A303 Sparkford – Ilchester dualling project

To: Examining Inspector, PINS,

From Sarah Bucks, Chair, South Somerset Bridleways Association

Our comments for DEADLINE 6

FIGURE 2.5  
HAZLEGROVE JUNCTION UNDERBRIDGE  
GENERAL ARRANGEMENT

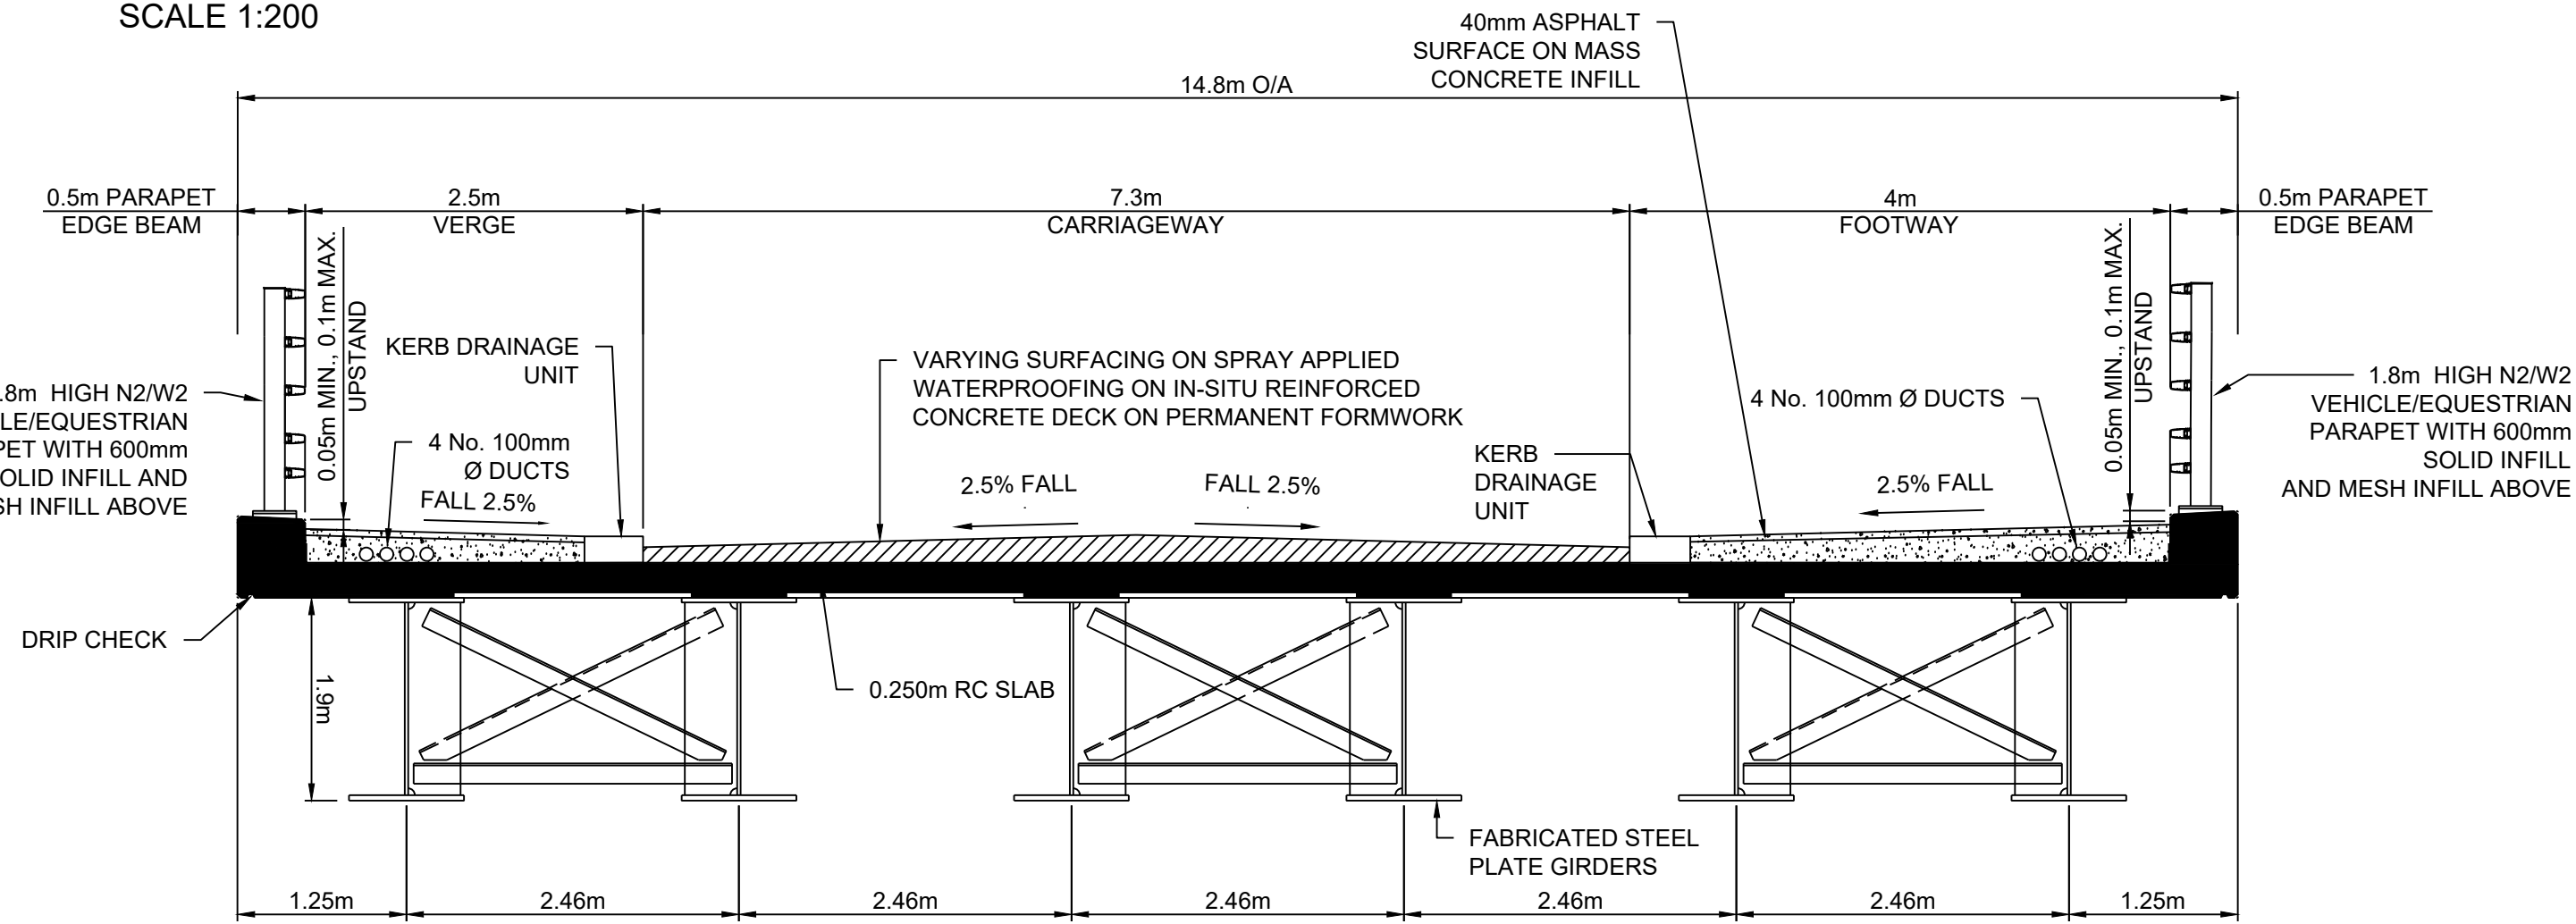
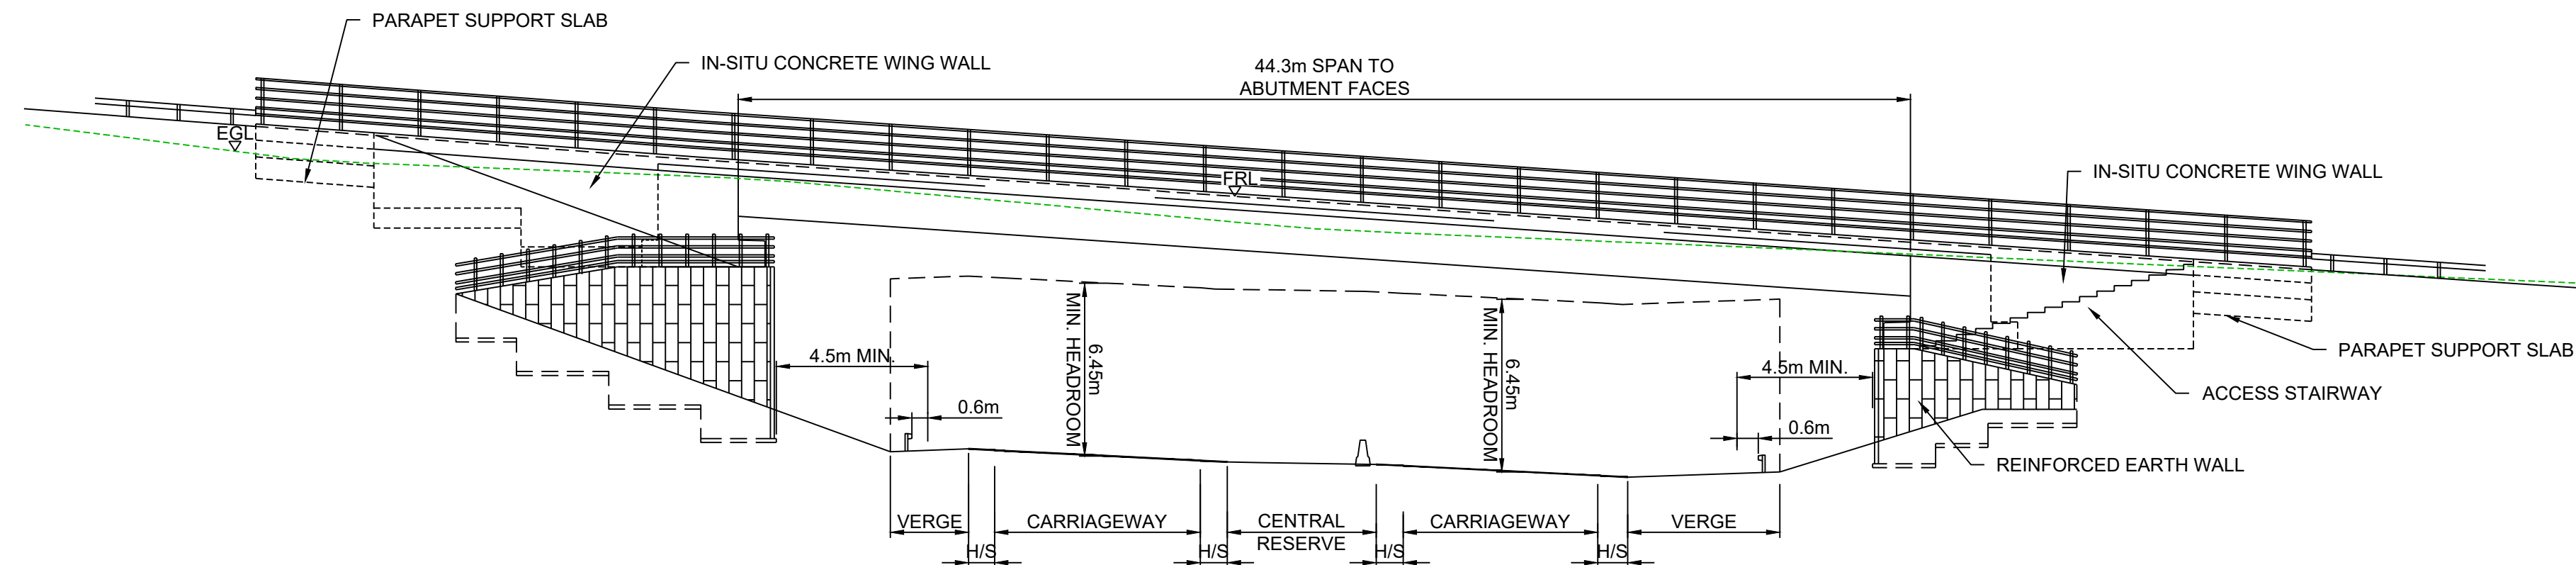
3.4.2 Please could attention be given in the detailed design to the noise inside the tunnel, in particular the vehicular road surface, and also the echoing within the tunnel.

3.6.7 The underbridge/tunnel. Ideally the NMU route should not be alongside the vehicular carriageways. Where this is to be the case, as much separation as possible should be designed. Raising the NMU surface well above oncoming headlights whilst not compromising the head height would be helpful, as would quiet surfacing on the vehicular carriageways and a non-echoing surface on the NMU route. Some sort of physical barrier is obviously essential and this should also have noise deadening properties. Lighting is important as vehicular headlights are often used in daylight and so disguising as much as possible with tunnel lights would be helpful.

## Routes affected by partial revocation of A303 Trunk Road (Sparkford to Ilchester Improvement and Slip Roads) (Side Roads) Order 1996

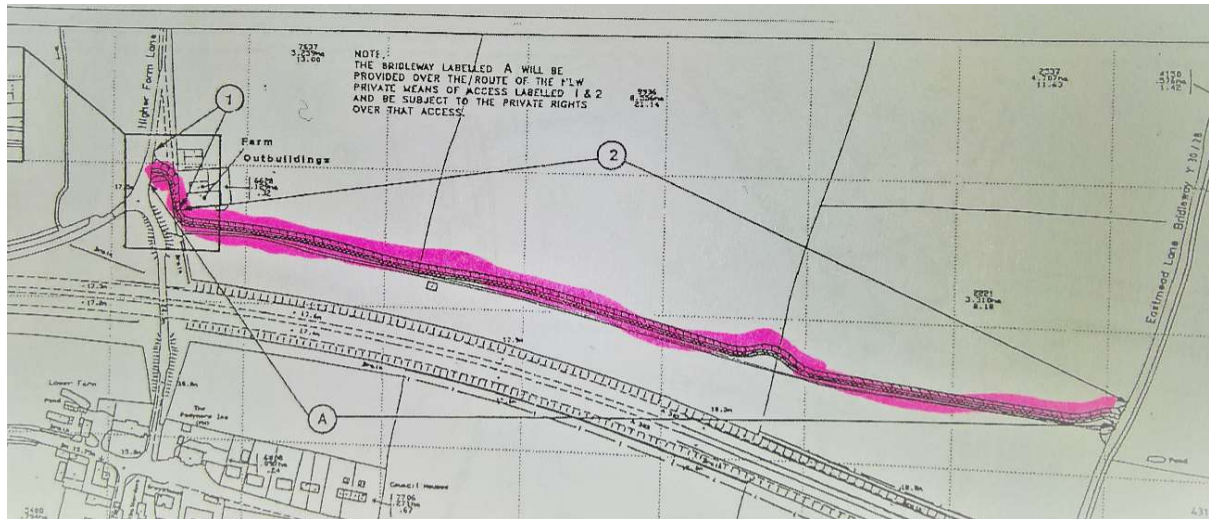
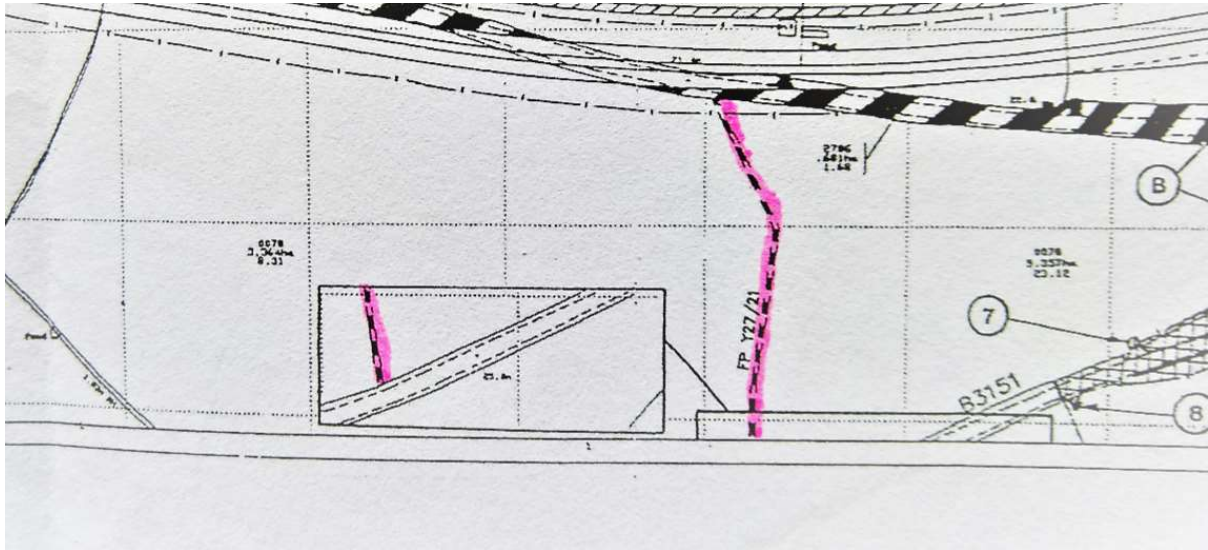
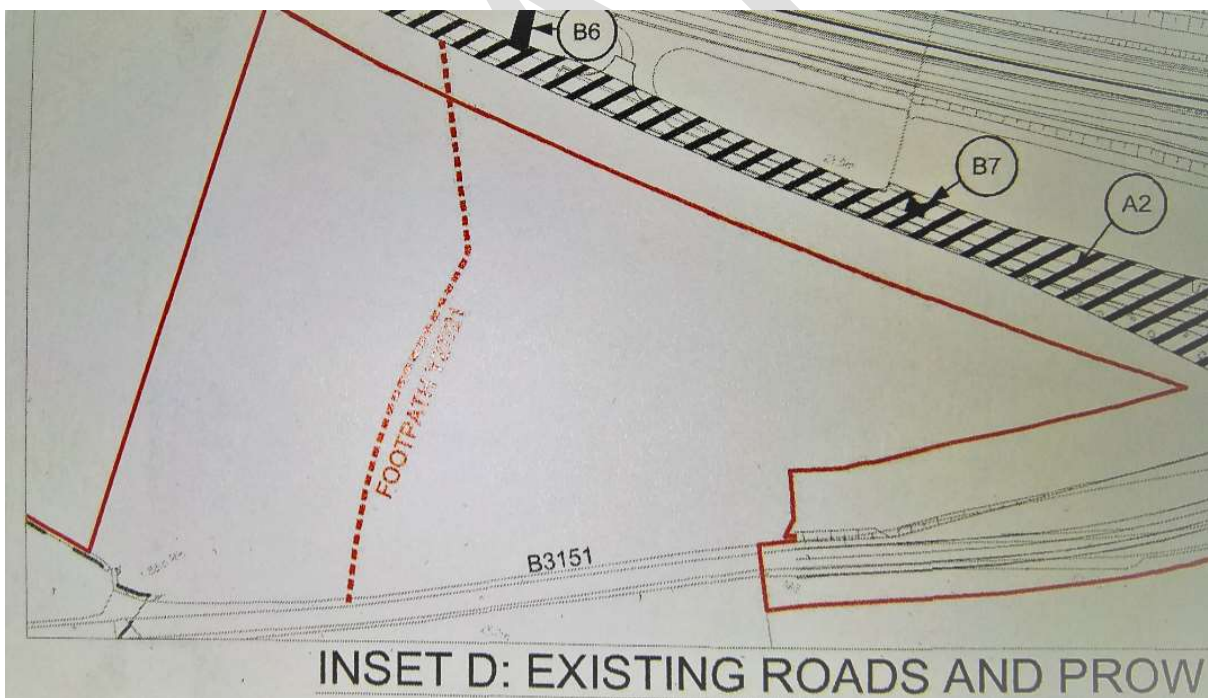
3.10.23 We too would like the situation between Podimore and Eastmead Lane resolved to produce an NMU link. We were disappointed at the hearing on Friday 1st. March 2019 to hear that the intention was to revoke, without consultation, the side roads order which created this bridleway. Such rights were negotiated in good faith over a couple of decades ago, and it is not the fault of the horse riders that the surveying authority has not had the resources to correctly record and put in

place this bridleway. It had always been assumed that the Higher Farm Lane road bridge carried public vehicular rights as suggested by the speed limit and dead end signage. A DMMO application which includes highway maintenance record evidence has been submitted. We would hope that a new NMU route would be dedicated within the DCO land envelope on the south side of the hedge to replace Y30/29 as not doing so would be contrary to all HE policies on connectivity and making provision for all road users including equestrians and cyclists. The connection between Eastmead Lane and Podimore depends on this bridleway.

Since Eastmead Lane connects two restricted byways and there is already a DMMO application to upgrade Eastmead Lane to a restricted byway, the link from Higher Farm Lane to Eastmead Lane should also be of restricted byway status. We would hope definitive routes could be sorted out as part of the works, and not left to chance after the new road has been completed.
